Ecology response

**From:** Jonathan Best <Jonathan.Best@arun.gov.uk>  
**Sent:** 30 April 2025 16:11  
**To:** Planning.Responses <Planning.Responses@arun.gov.uk>  
**Cc:** Emma Sheppard <Emma.Sheppard@arun.gov.uk>  
**Subject:** BE/16/25/RES

Land at Oldlands Farm Newlands Road Bognor Regis PO22 9NN.

Recommendation: Refuse due to failure to meet the recommendations of the Ecological Impact Assessment (The Ecology Co-op, November 2022) for bats, birds and reptiles.

DRAINAGE STRATEGY IMPORTANT NOTES

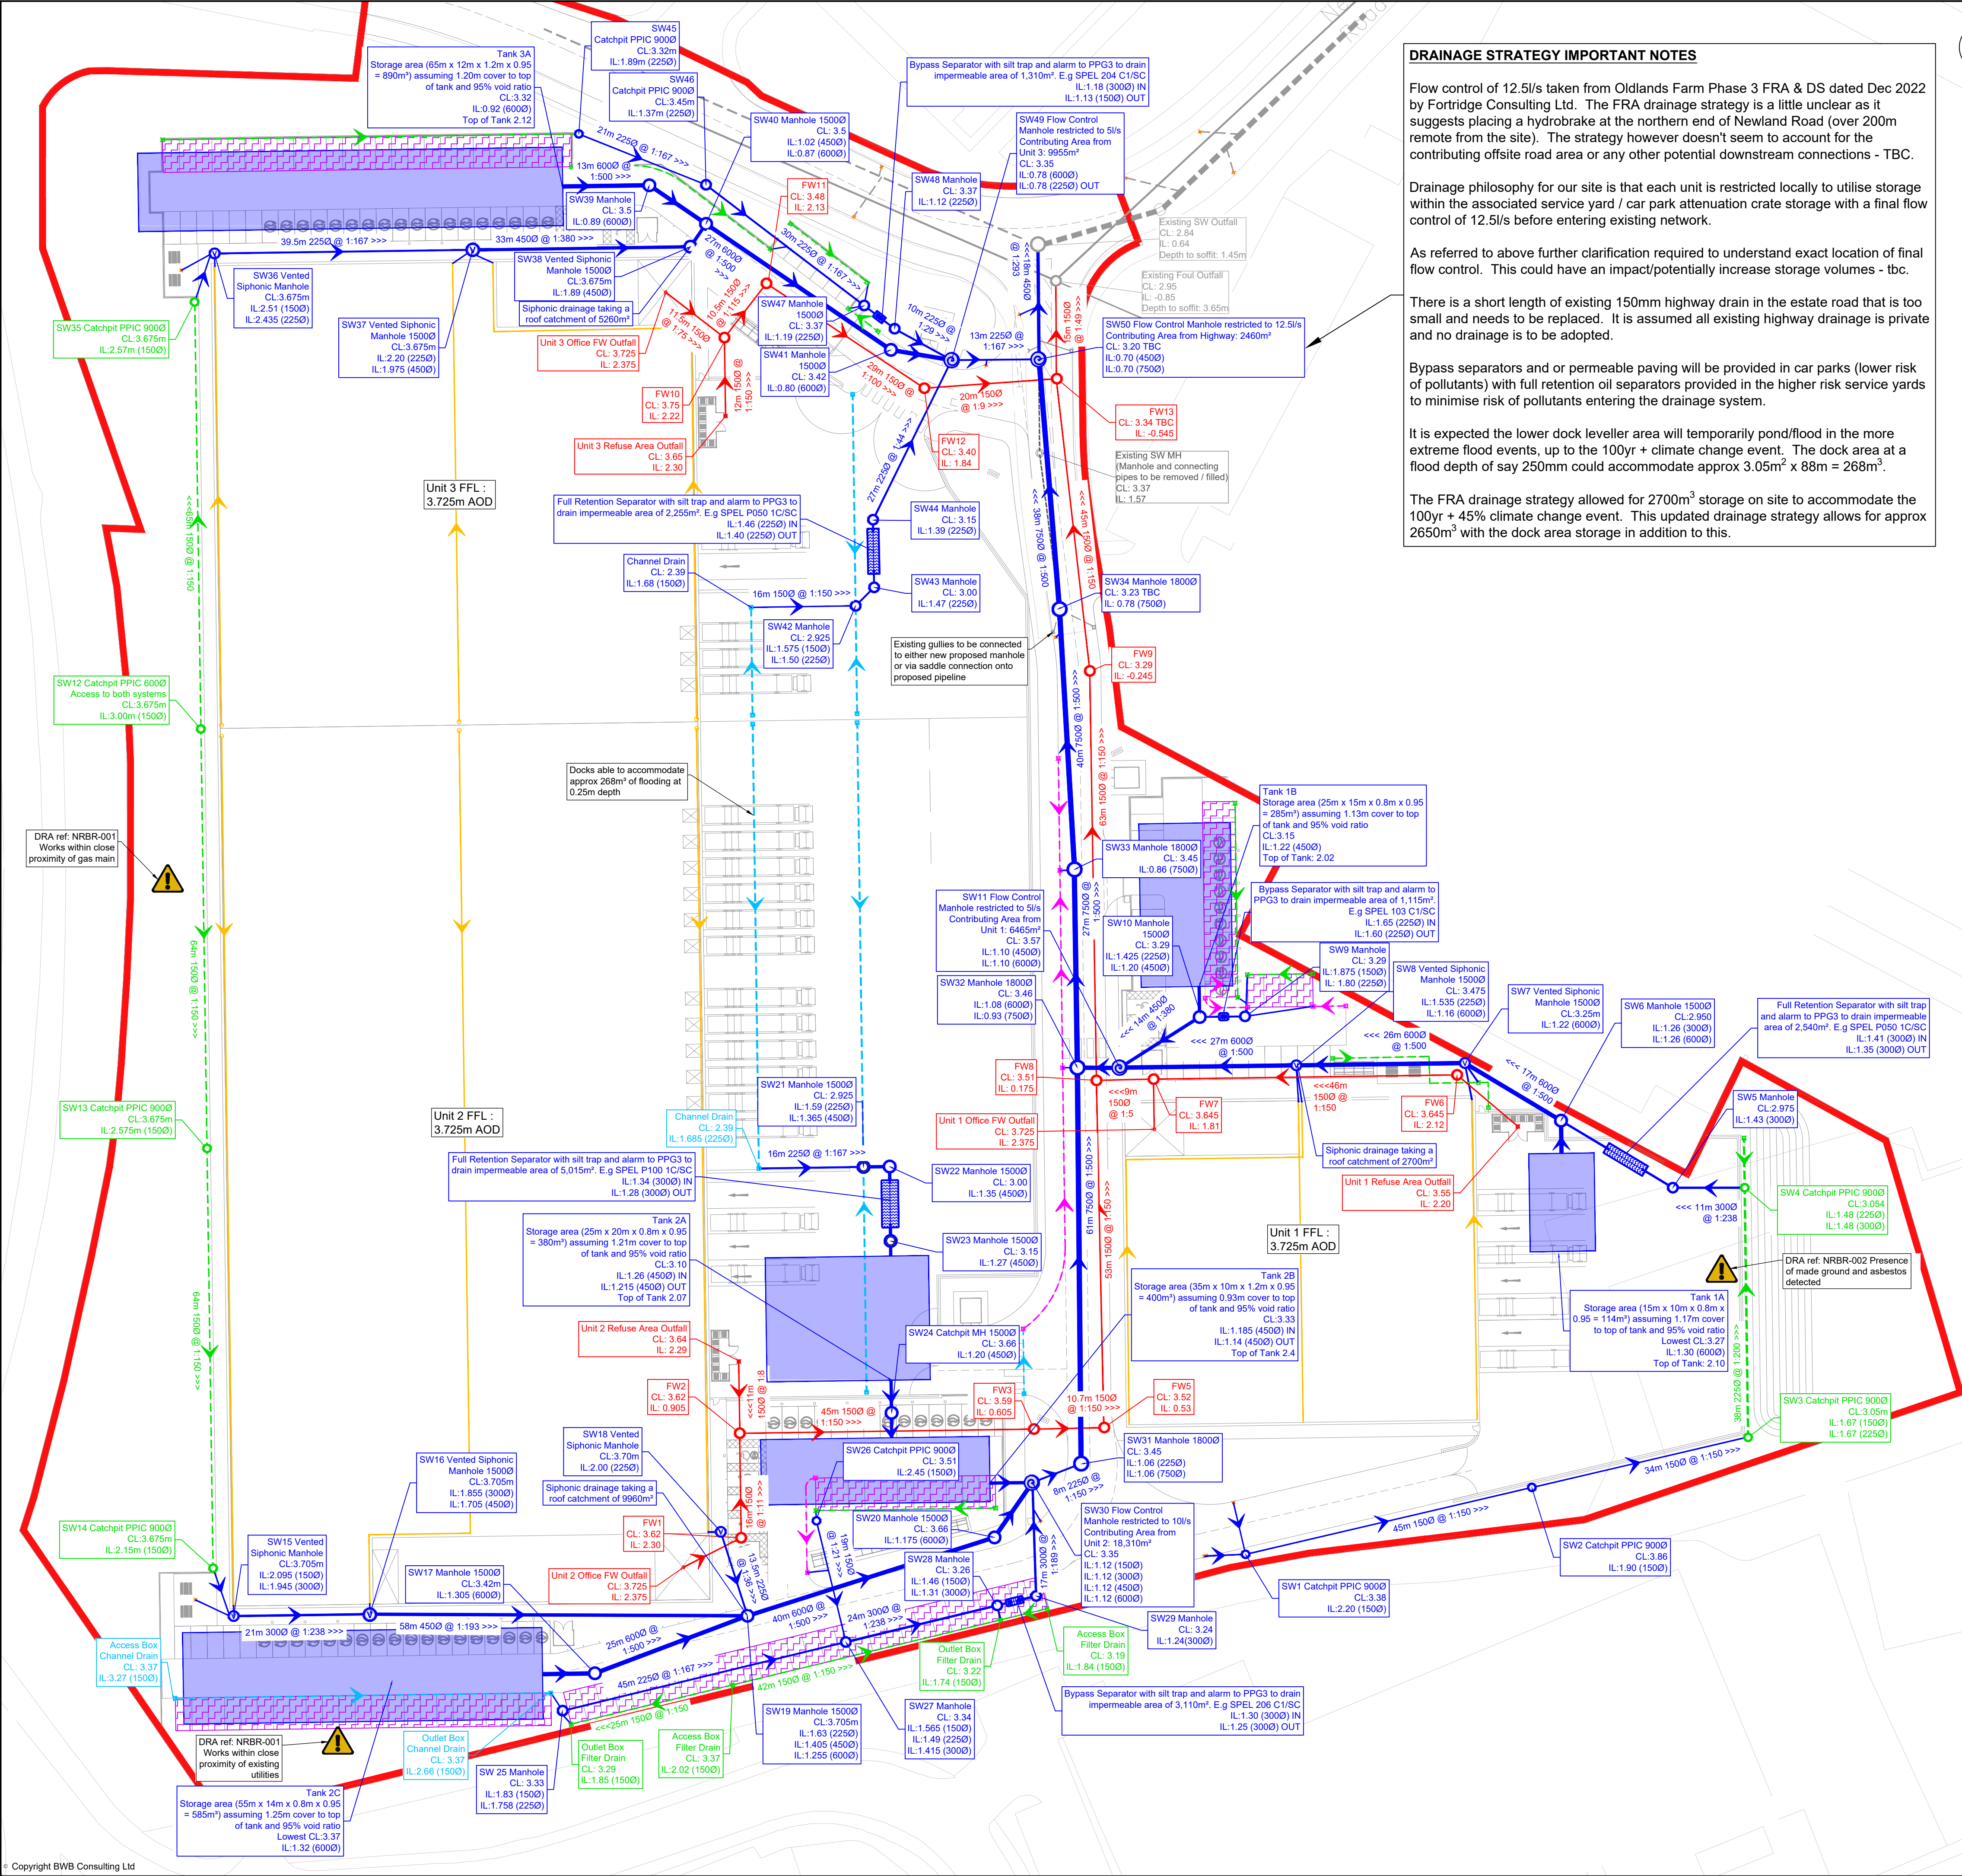
No SUDs features are identified within the submitted site plans for this application.
